THE SIZEWELL C PROJECT

DEADLINE 5

THE HEVENINGHAM HALL ESTATE (HHE)

THE DCO & s.106

DRAWING TITLE:
PLAN 1J(a)
YOXFORD ROUNDABOUT
SITE PLAN

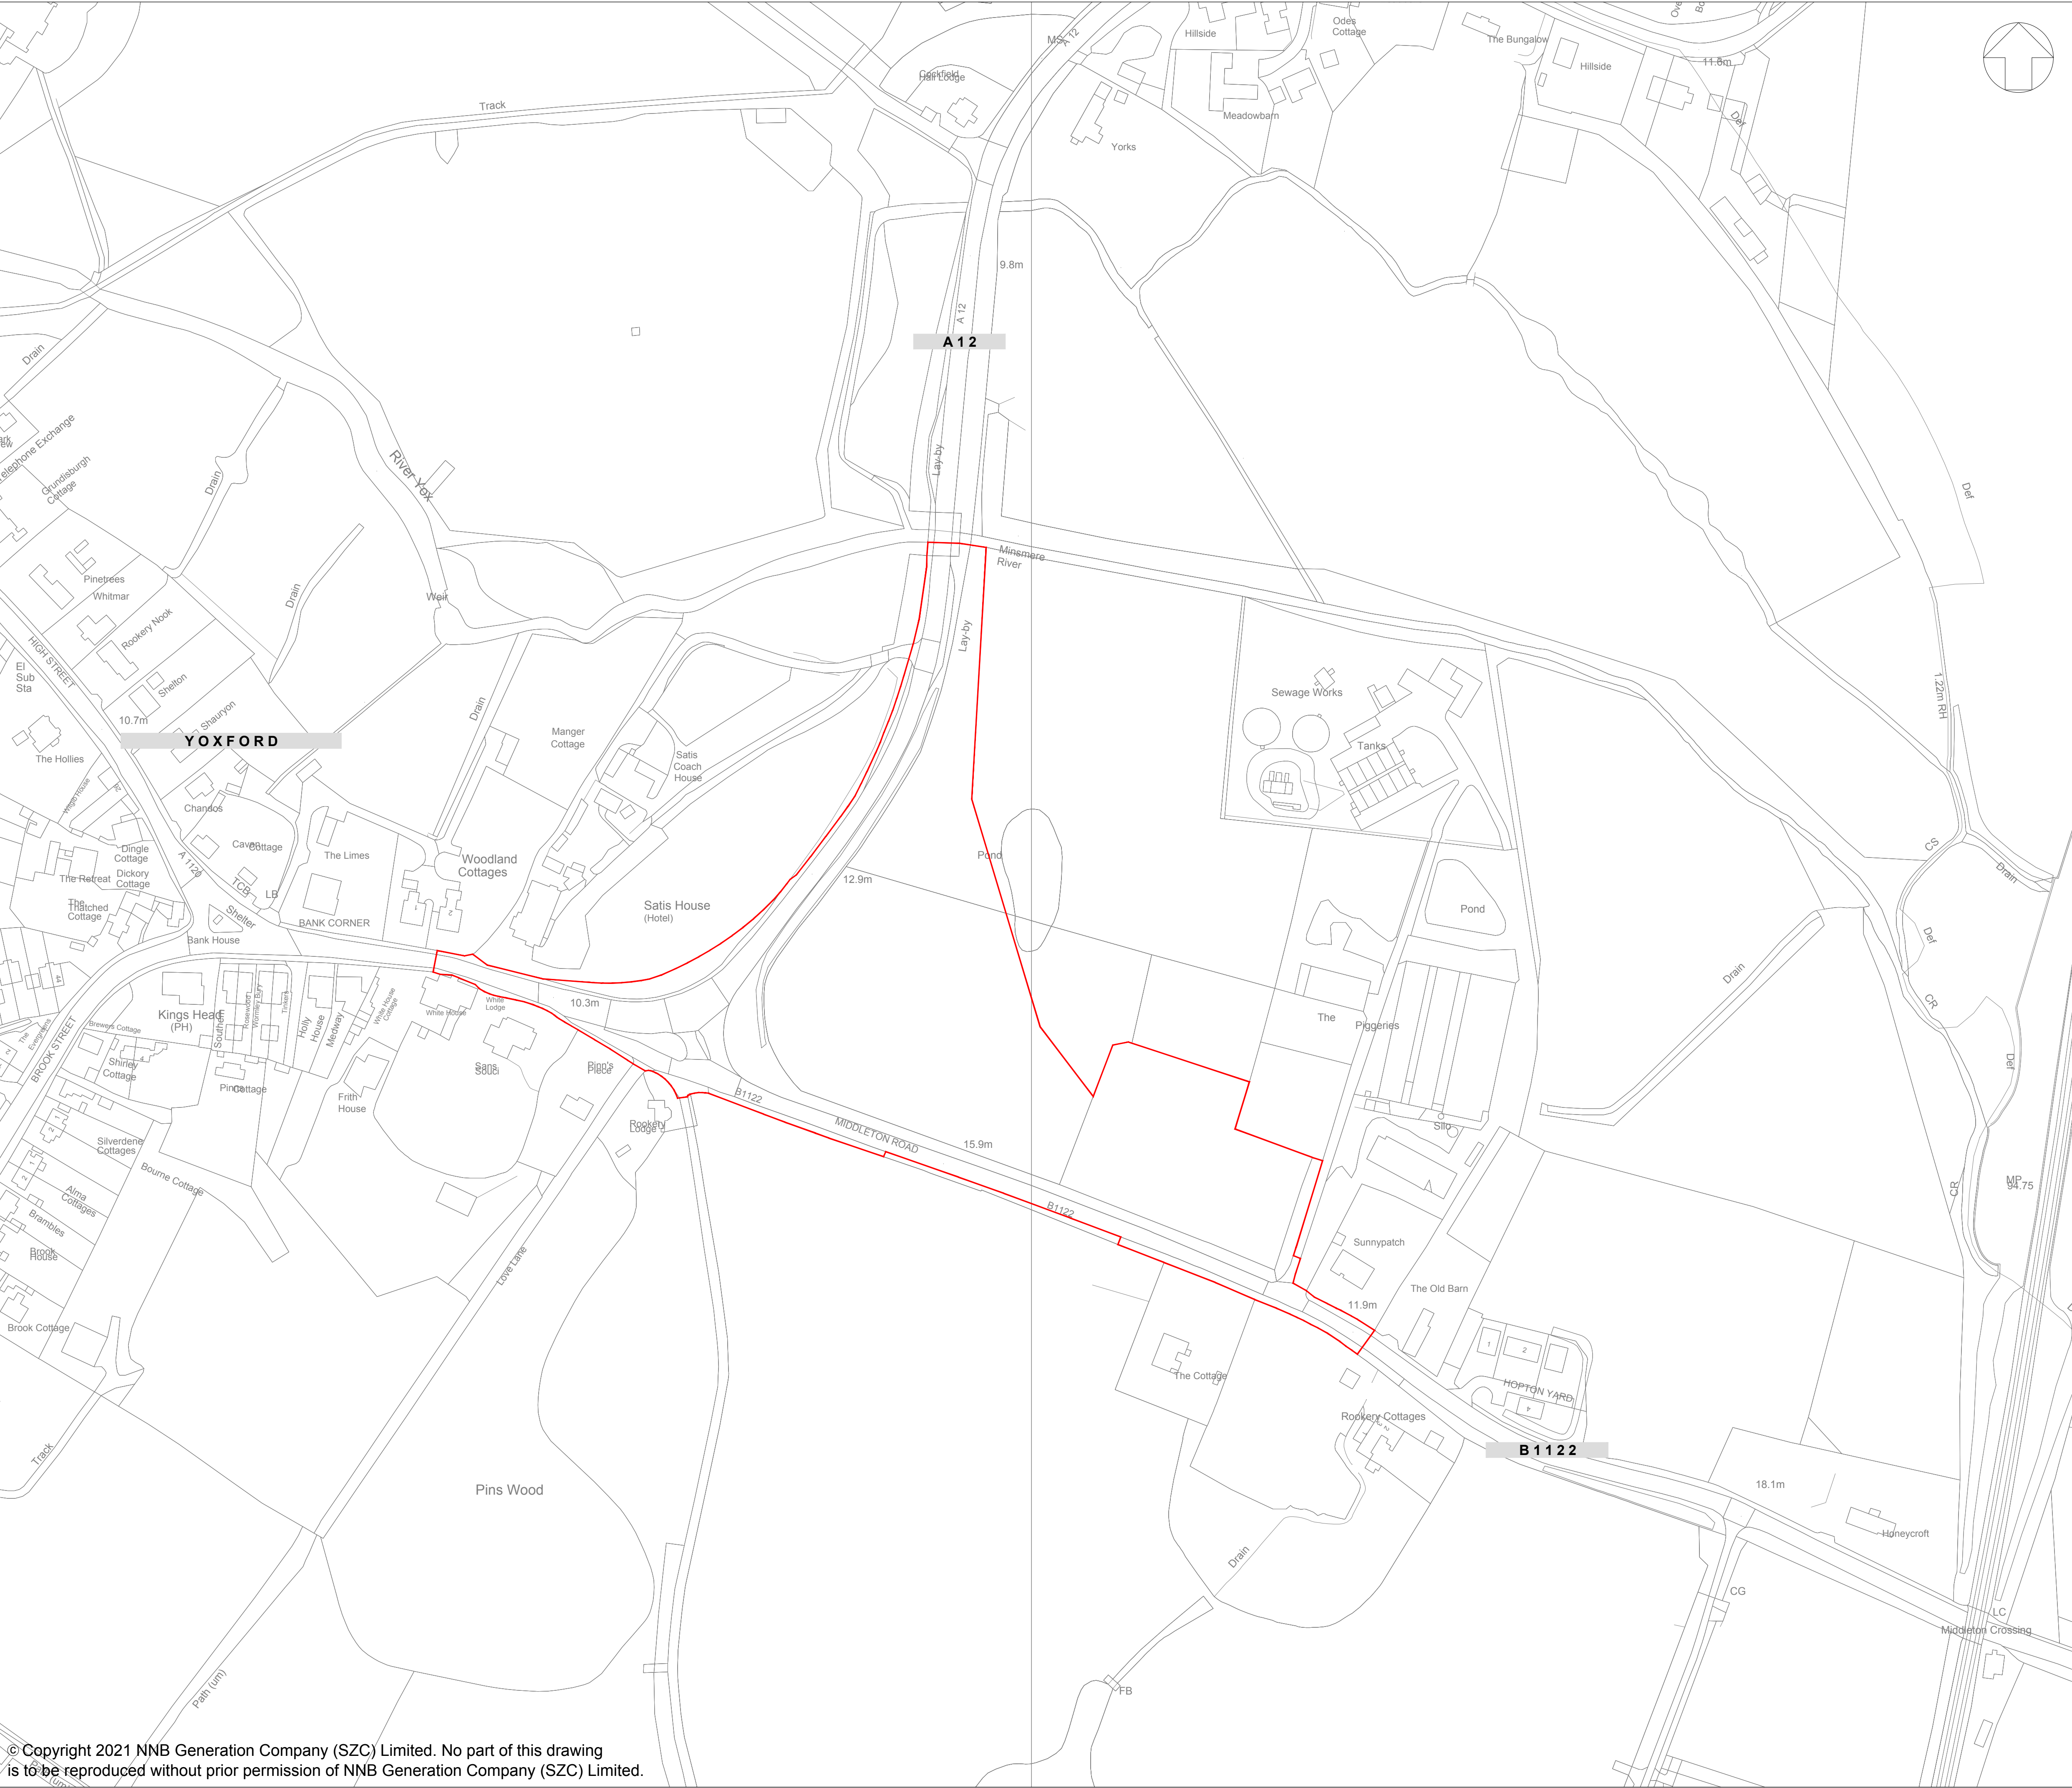
Req 28 - proposed new Req - YR	Amendments to the YR sought post construction to make it smaller and remove the AIL route	Not accepted. Art 21 applies. The YR forms part of HE’s “heavy load route 100”.	SZC Co. state and the HHE accept that a 55m diameter roundabout will be required during the operation and decommissioning of Sizewell B and Sizewell C “from time-to-time” i.e. its use will be required occasionally. Given the visual impact that such a large roundabout has, particularly the heritage impacts on the Cockfield Hall complex and the Yoxford Conservation Area, the HHE suggest that the YR is reduced in size, but the

full 55m retained as highway land and soft landscaped. TPA the HHE's transport consultant have done a preliminary sketch for a 40m diameter roundabout (still very substantial), which indicates that AIL's of the size proposed would still be able to navigate it quite satisfactorily. See also the HHE's written submissions on ISH2 and ISH3.
Req 29 - proposed new Req – protected species	Seeks protection for unexpected protected species	Not accepted. Duplicated existing controls, see Req 4, and CoCP.	<p>On balance, the HHE accepts SZC Co's position.</p> <p>The HHE accepts that an <i>“unexpected discovery made of protected species”</i> is covered in the CoCP at para 2.2.8 (Part C, page 10) and that this is to be notified to Natural England <i>“in the event of the identification and disturbance to a suspected protected species of animal, plant or habitat.”</i> And that <i>“SZC Co. will consult with the relevant stakeholders on the appropriate course of action, including advice on further remediation”</i>. This doesn't go quite as far as the HHE had requested in Req 29, but it is accepted that SZC Co could not undertake works without a protected species licence if one was required. This is recognised at CoCp para 6.1.4, Part C, page 34.</p> <p>The HHE is aware on its own estate of protected species that SZC Co. do not necessarily have a remediation plan in place for in relation to the NPR and YR, and are anxious that appropriate remediation is secured as required.</p>
